Our Ref: M/89/19/HH
Your Ref:

Town & Country Planning Act 1990 (as amended)
Town & Country Planning (Development Management Procedure) (England) Order 2015
Application for Planning Permission for Works or Extension to a Dwelling

Development Front porch, enlarged dormer to rear and boarding to first floor elevations
Location 3 Sea Way Middleton-On-Sea

Project:	
Proposed alterations; 3 Sea Way, Middleton on Sea	
PO22 7RZ	
Drawing:	
Second floor and roof proposed, block plan	
For:	
Mr. & Mrs. R. Abbott	
Drawn:	Date:
PKS	September 2019
Scales:	No:
1:50 1:100 1:500	2490/01/06
To scale when printed on A3

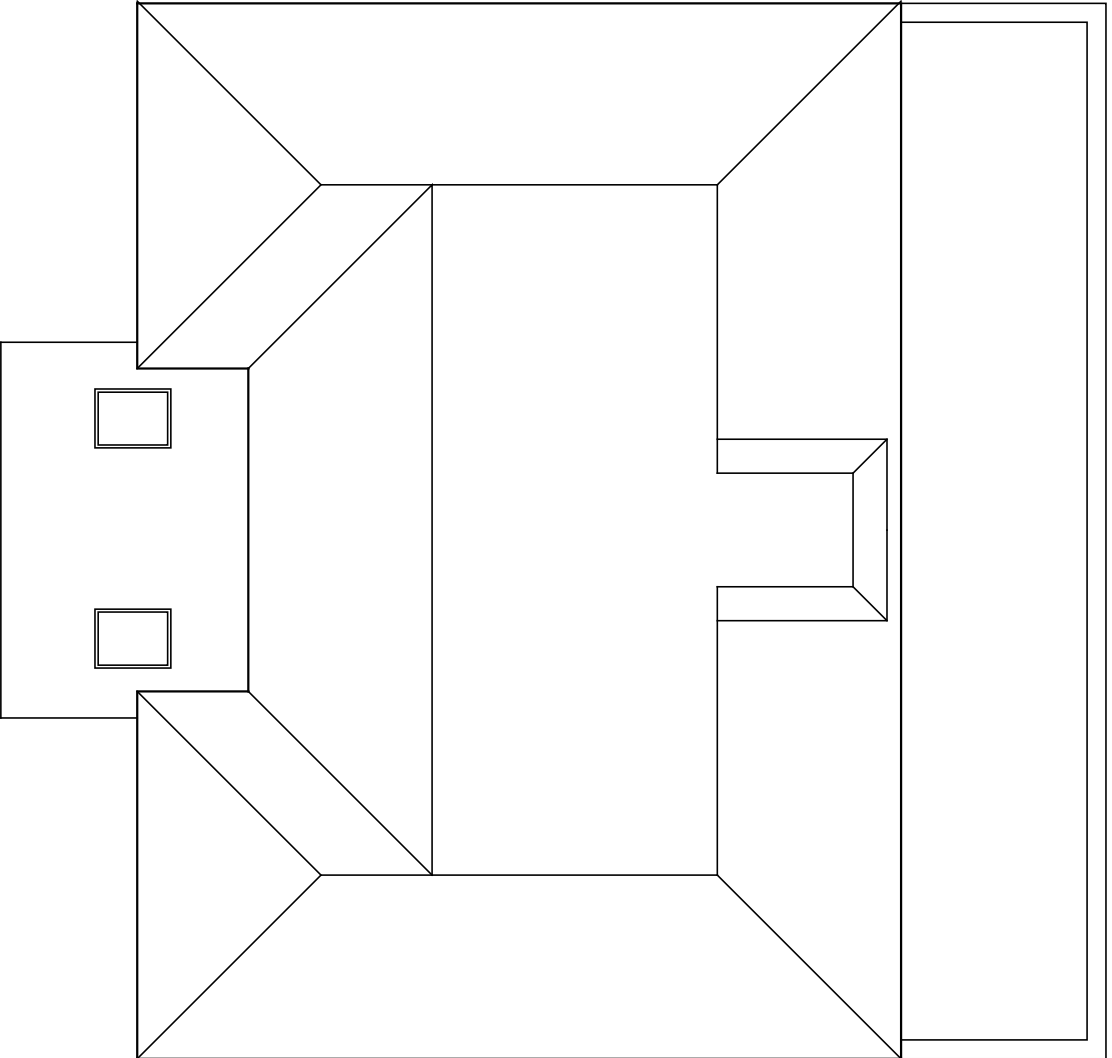
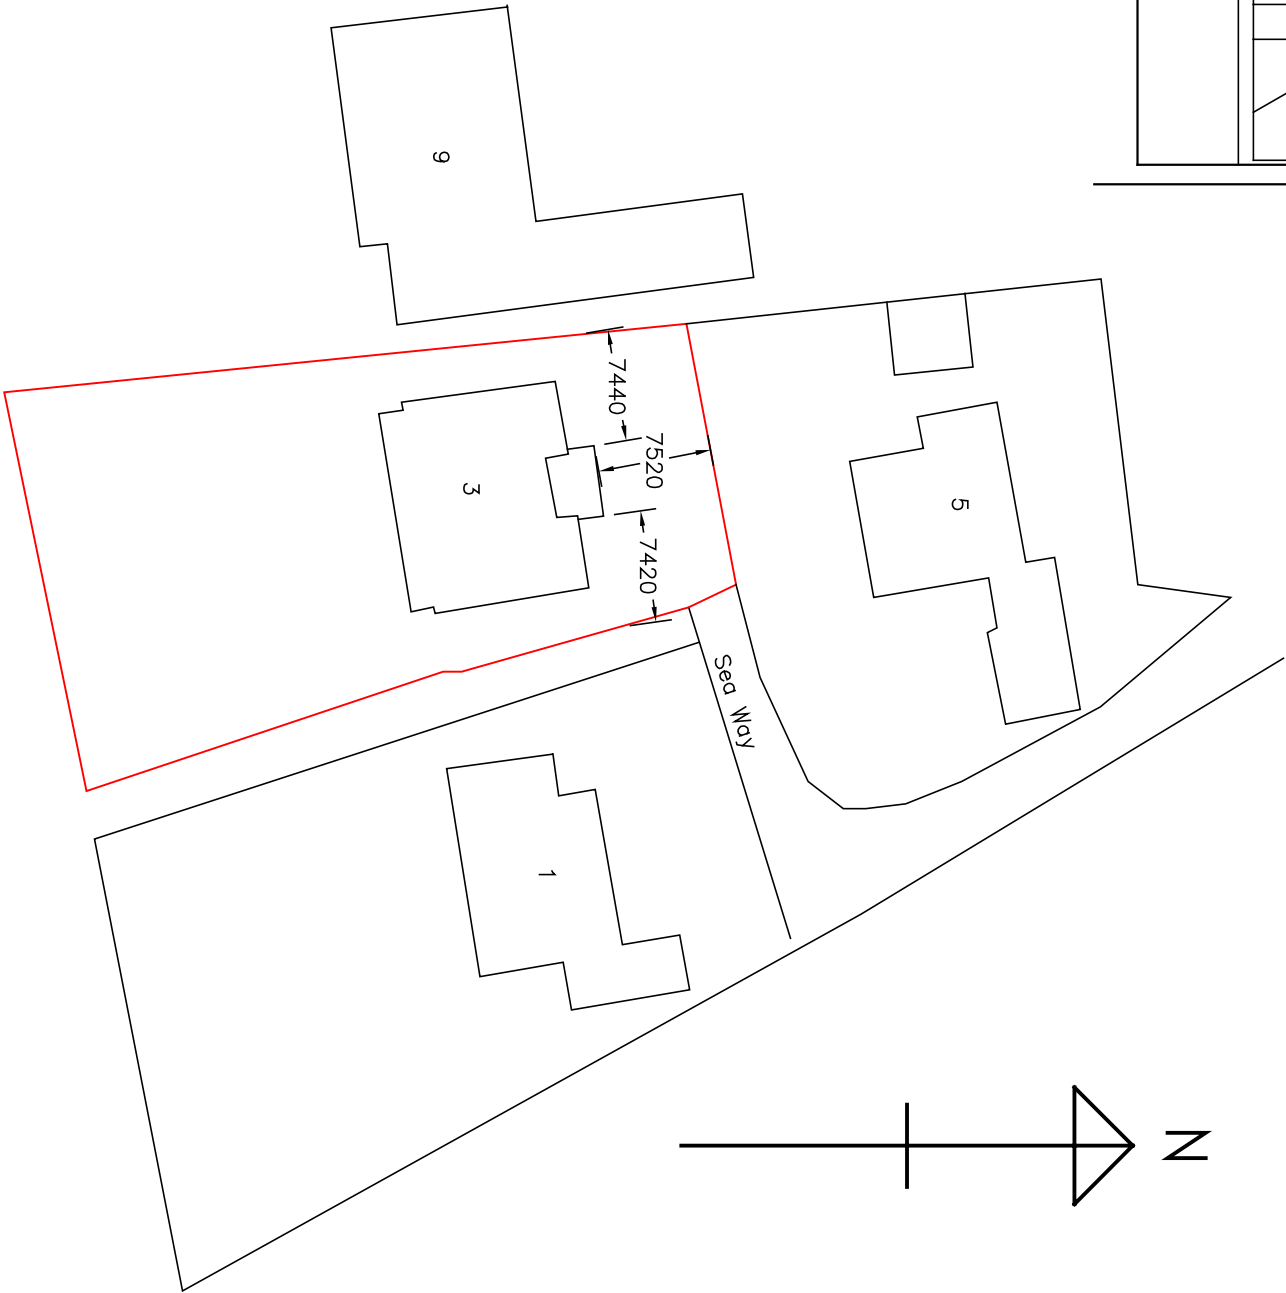
Room Labels: You are required to have room labels on your floor plans. Please amend.
Flood Risk Assessment
